Thurrock Power Ltd Comments on Natural England's Deadline 2 Submission

Deadline 3

Figure 5.15.4. Mudflat –within and adjacent to the TFGP site

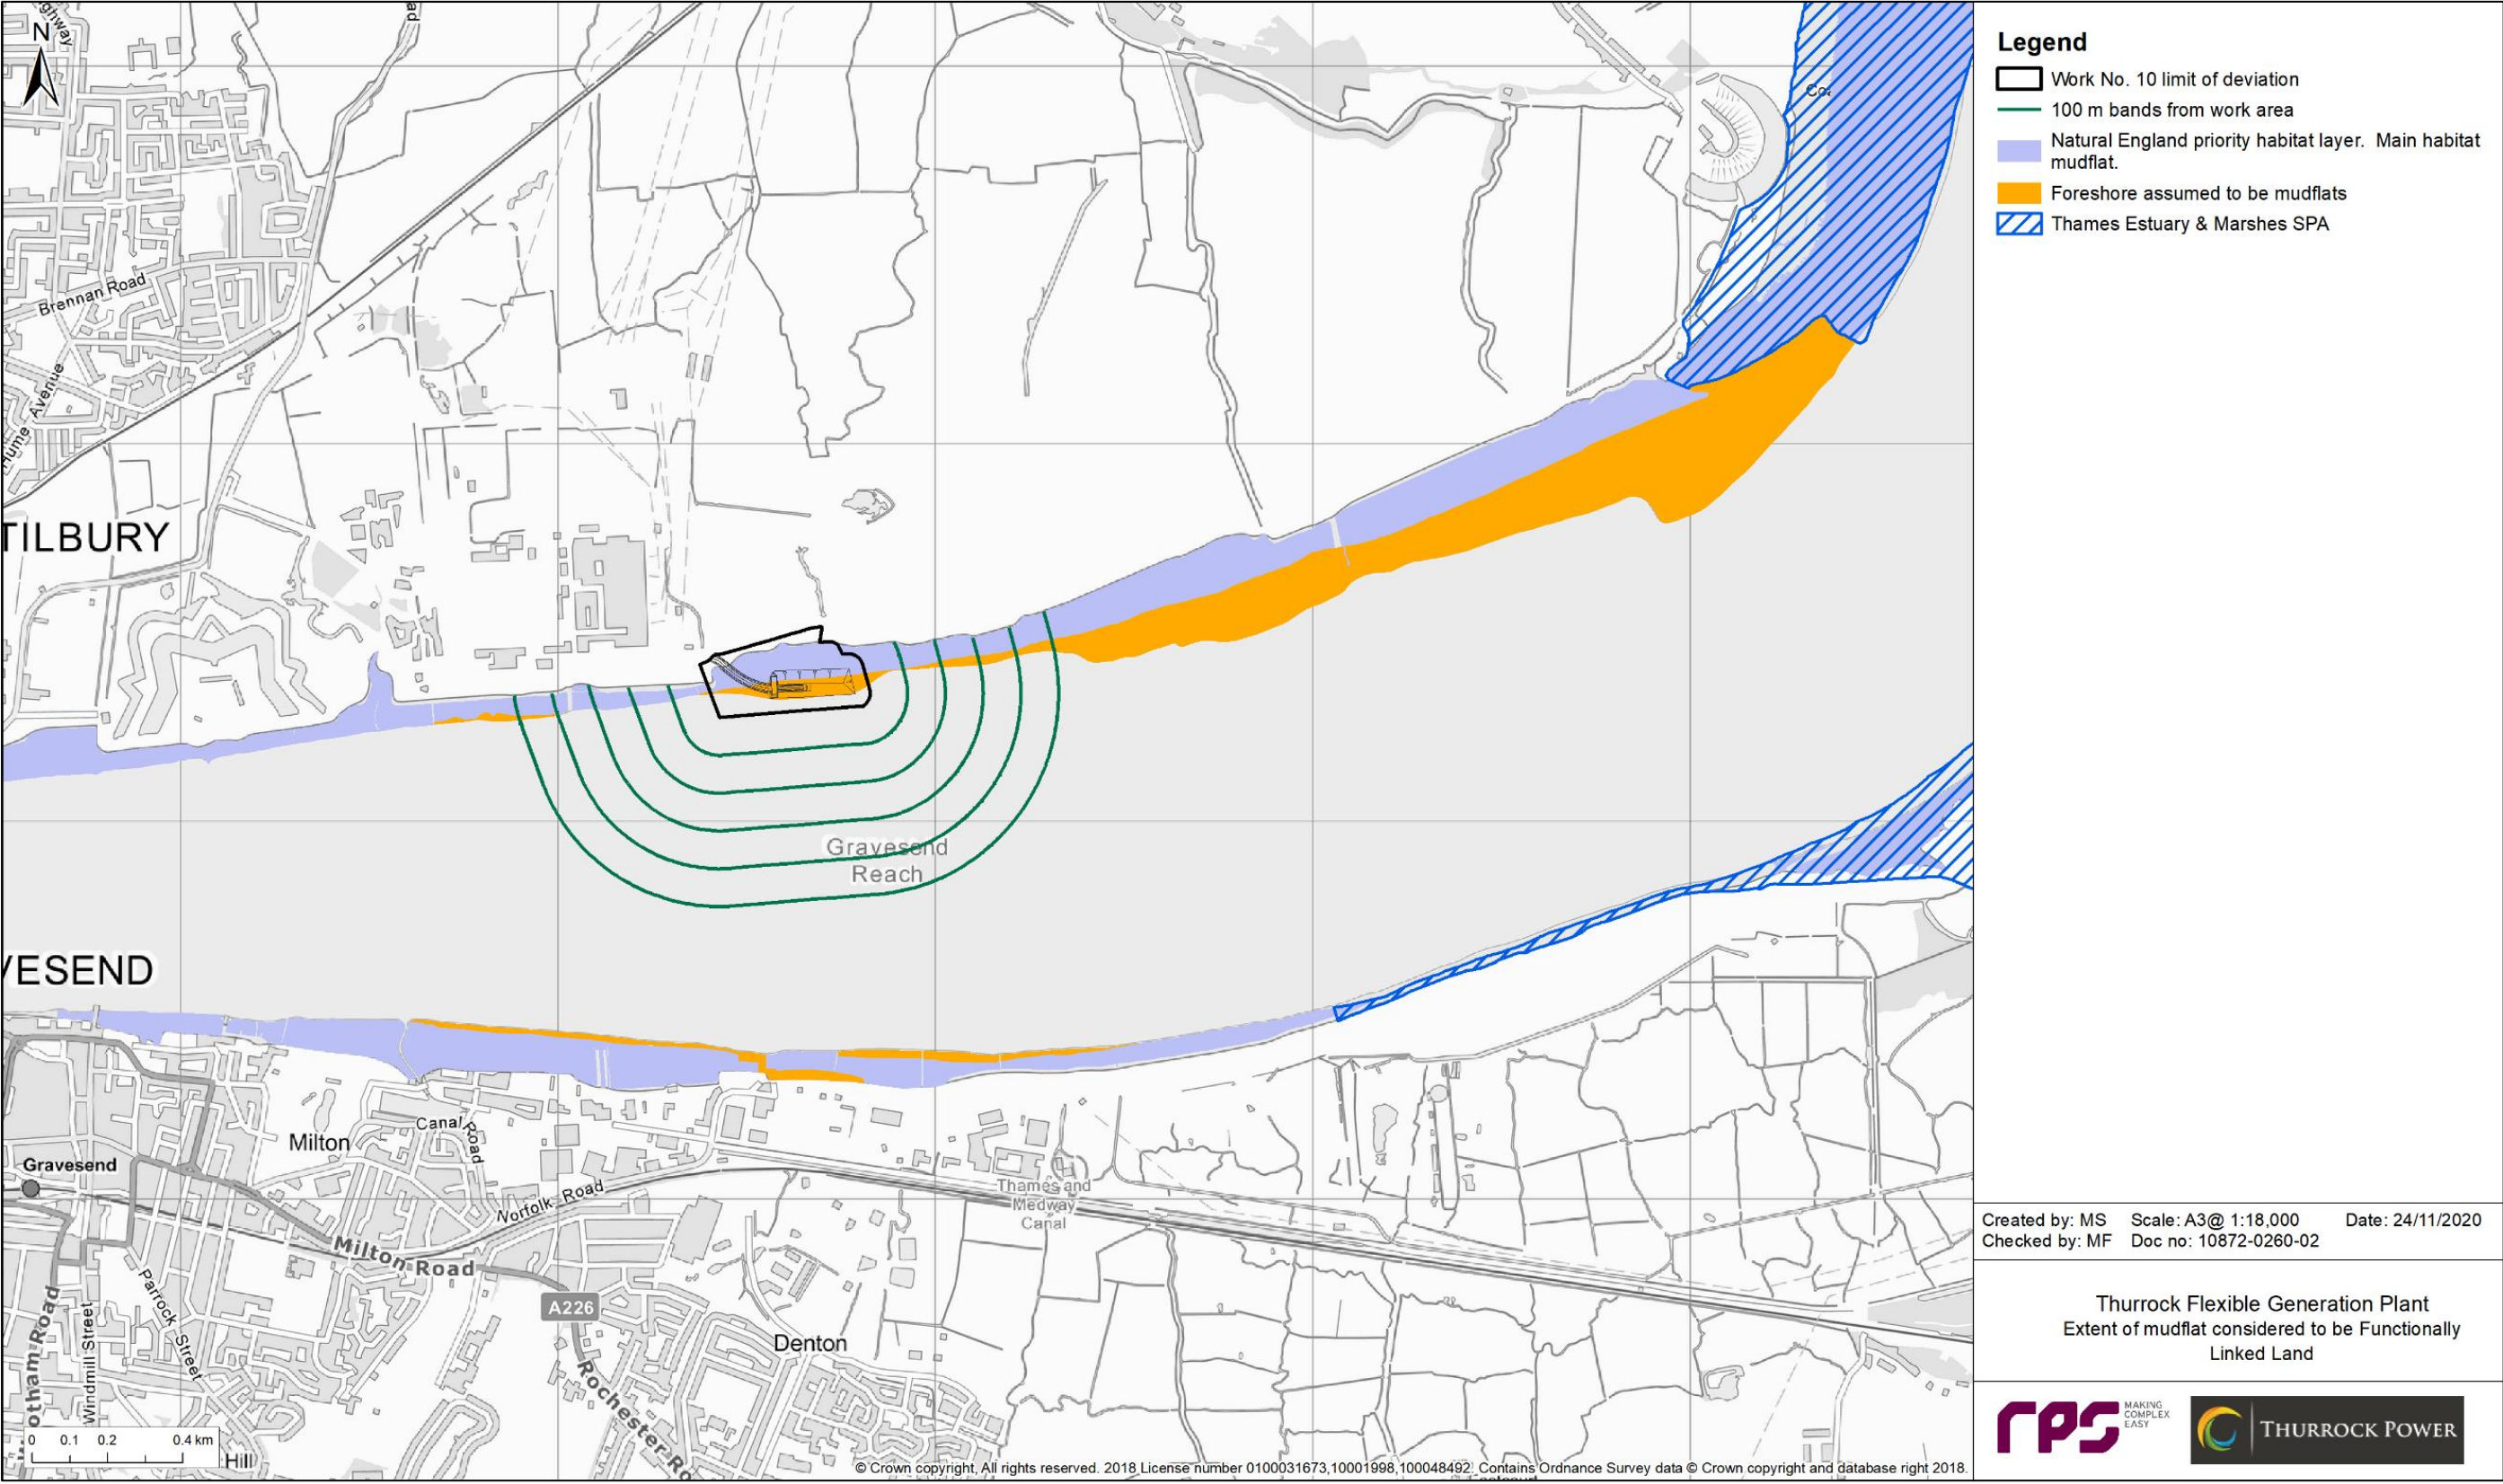
3e	The losses in this case are neither very small (to be dismissed as not significant) - at 0.35ha for the longest-term loss to the causeway - nor are they so extensive as to present a compelling case for an effect on site integrity	The Applicant maintains its position that the loss of 0.35 ha mudflat outside the SPA boundary is not significant, but we would refer back to Item 1 where the Applicant is proposing to discuss this matter further with NE.
	3f	The area is located towards the upper foreshore where available food resources begin to diminish as the tide covers the mudflats. Such areas represent the last available feeding opportunities until the tide recedes, carrying arguably greater energetic importance.	The Applicant maintains that its surveys demonstrate that the use of the mudflats by Redshank, Ringed Plover and Dunlin is sporadic regardless of the tidal period. Avocet use of the site is more consistent but again our position is that the effects of the causeway would not result in an AEOL.
